NNF22

Response to RSP's response to ExA4WQ Ns.4.3
Noise contours produced by the Civil Aviation Authority for
No Night Flights

5th July 2019

Figure 12.9
Aircraft noise - night-time L_{ASmax}
contours - year of forecast maximum
capacity

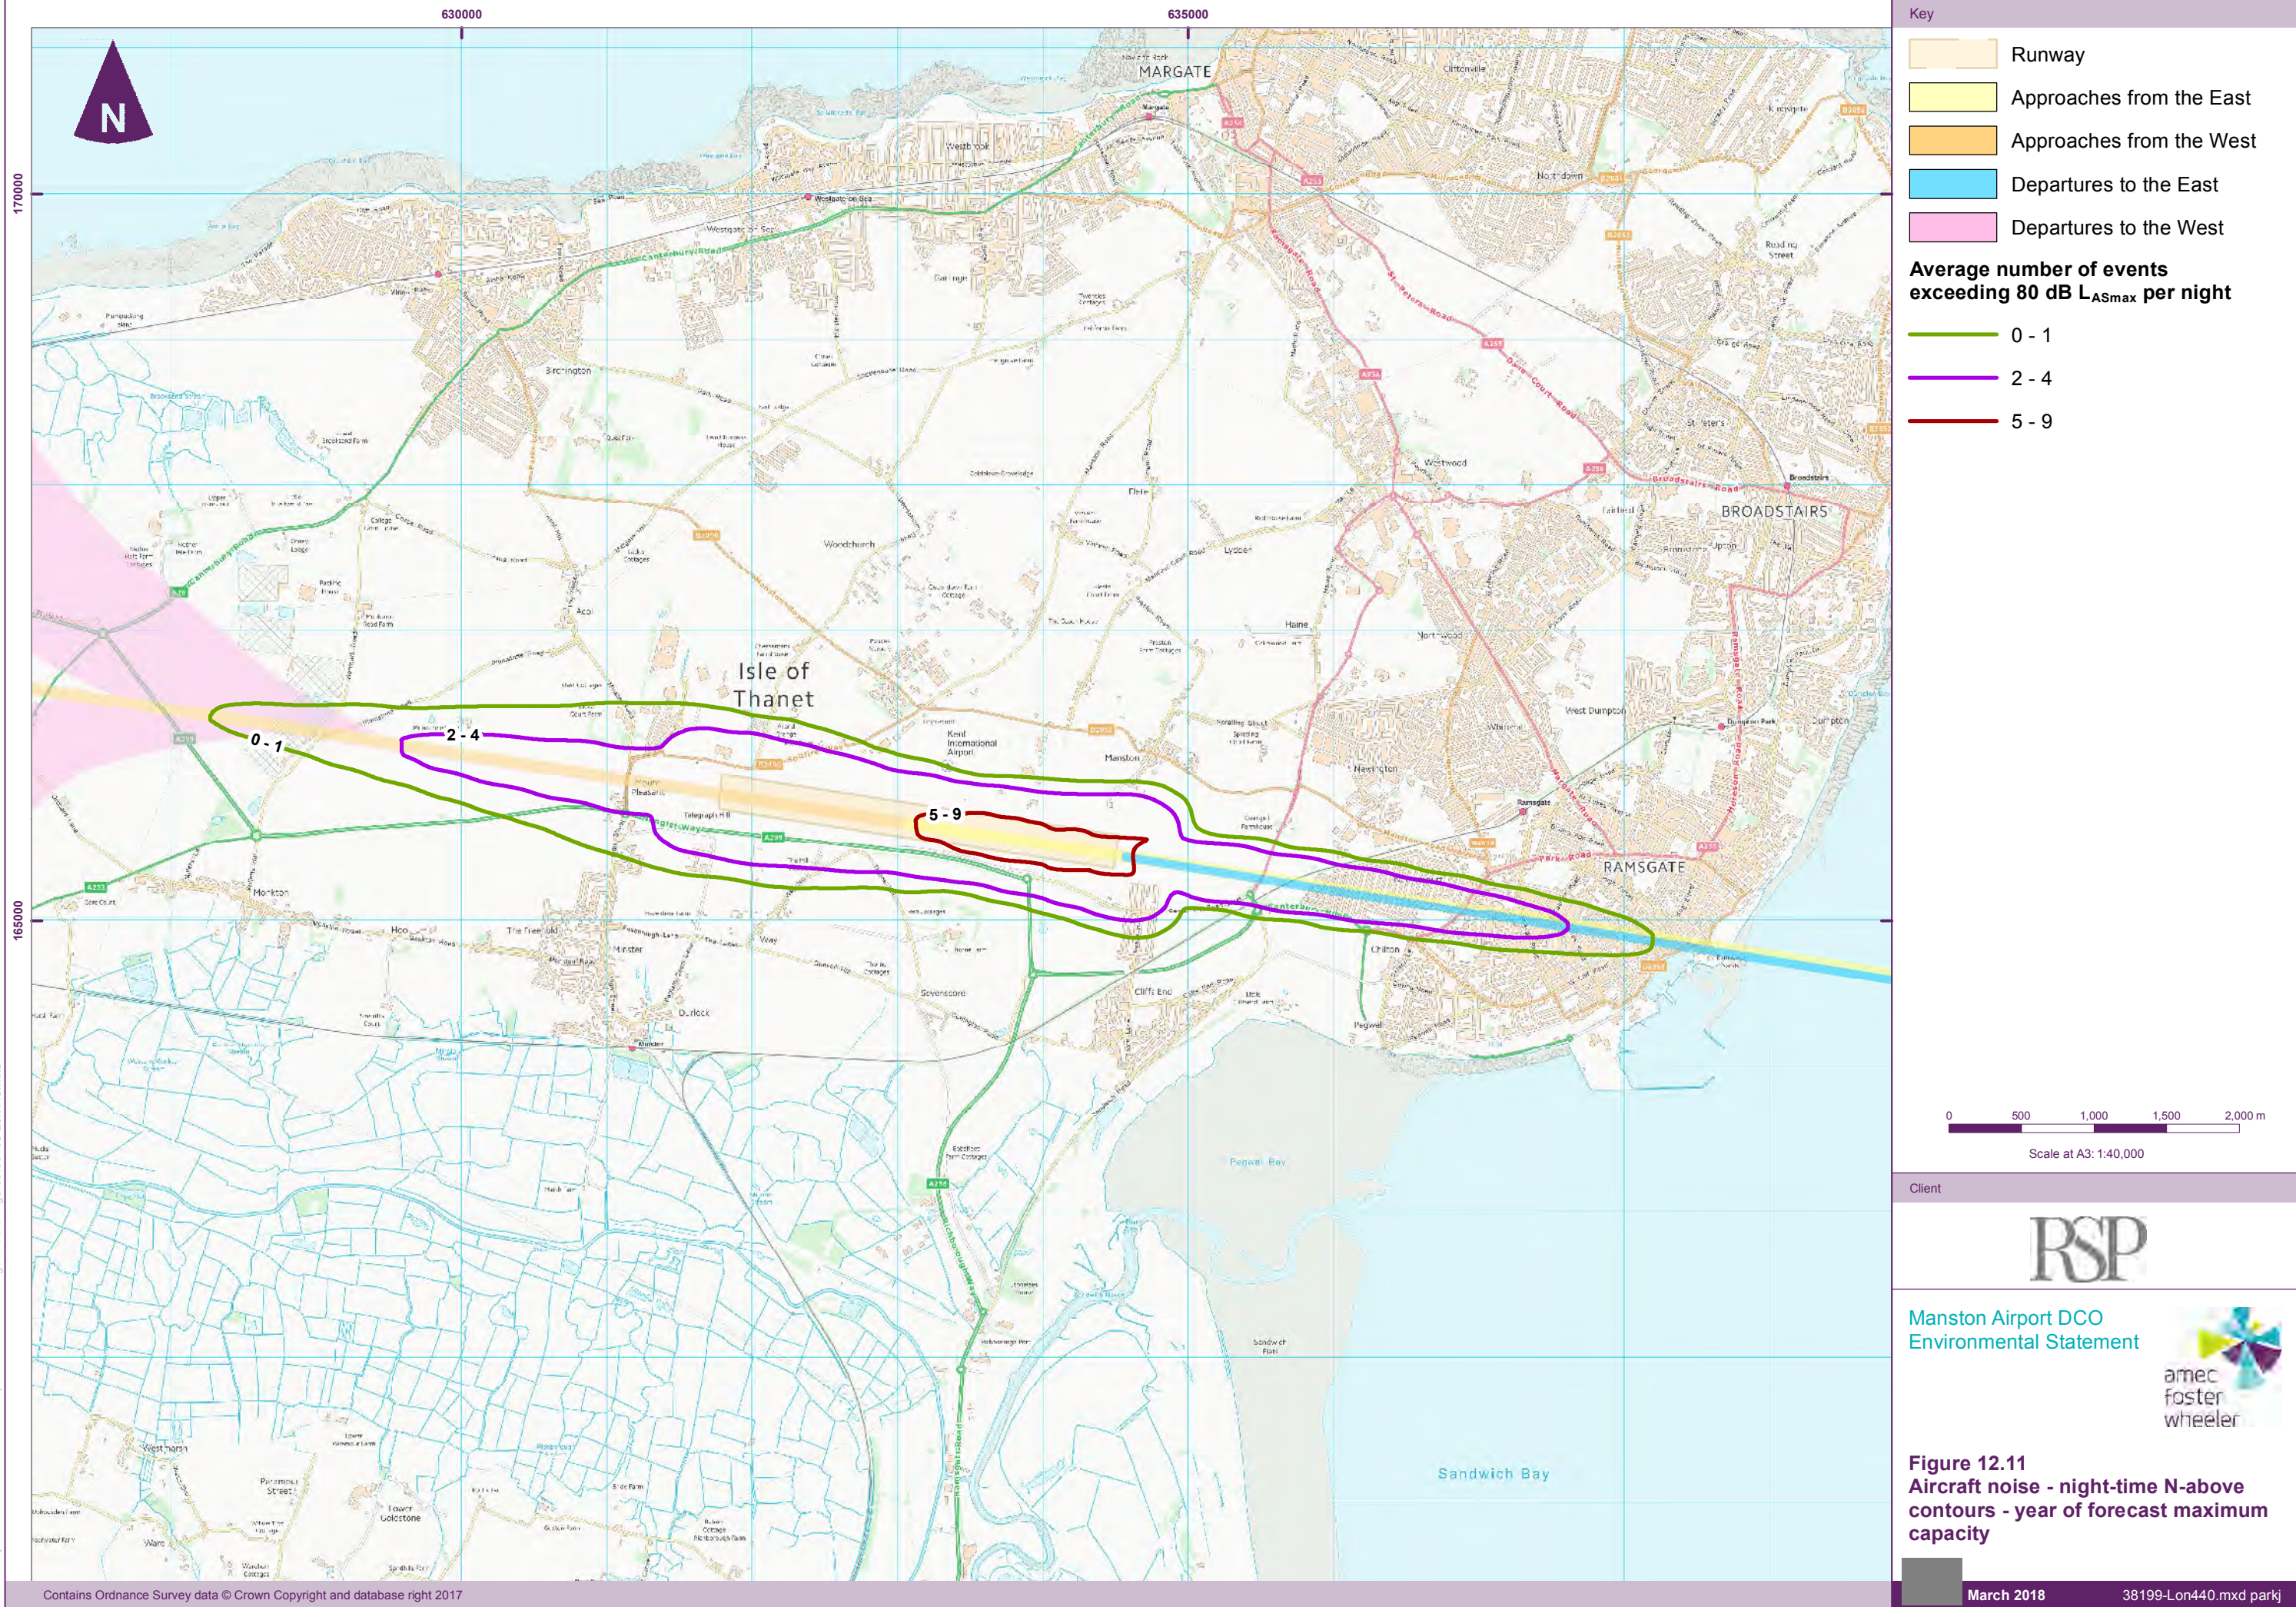
23. The Applicant says that there may be a difference between its profiles and NNF's because the ANCON database assumes average weights. In Appendix 12.3 to the Applicant's ES [APP-057], the Applicant says that the INM system that it used does not have a setting for aircraft weight. It relies instead on assumptions about the length of the stage that the aircraft has flown. It says that that stage length is only applicable to departing aircraft. For example, if an aircraft is going to the US, it will be heavier than if it were going to Norway (all other variables being equal) because it will be carrying more fuel. This suggests that in the Applicant's model no account is taken of the fact that the Applicant's own operating assumption is that a disproportionate amount of cargo that would be handled by its proposed airport would be imported, therefore would be relevant to arrivals. Our contention is therefore that RSP's contours underestimate the weight of arriving freight aircraft.

45. We note with increasing disbelief and horror that far from introducing a ban on night flights, RSP is seeking an even greater level of flexibility for night flights in the latest iteration of its Noise Mitigation Plan. **The night noise contours produced for NNF by the CAA do not in any way begin to capture the night noise impact that would be generated by the operational freedom that RSP is now seeking to apply its suggested annual quota count to just one hour of an 8 hour night.** We will say more about this in our response to the latest Noise Mitigation Plan.
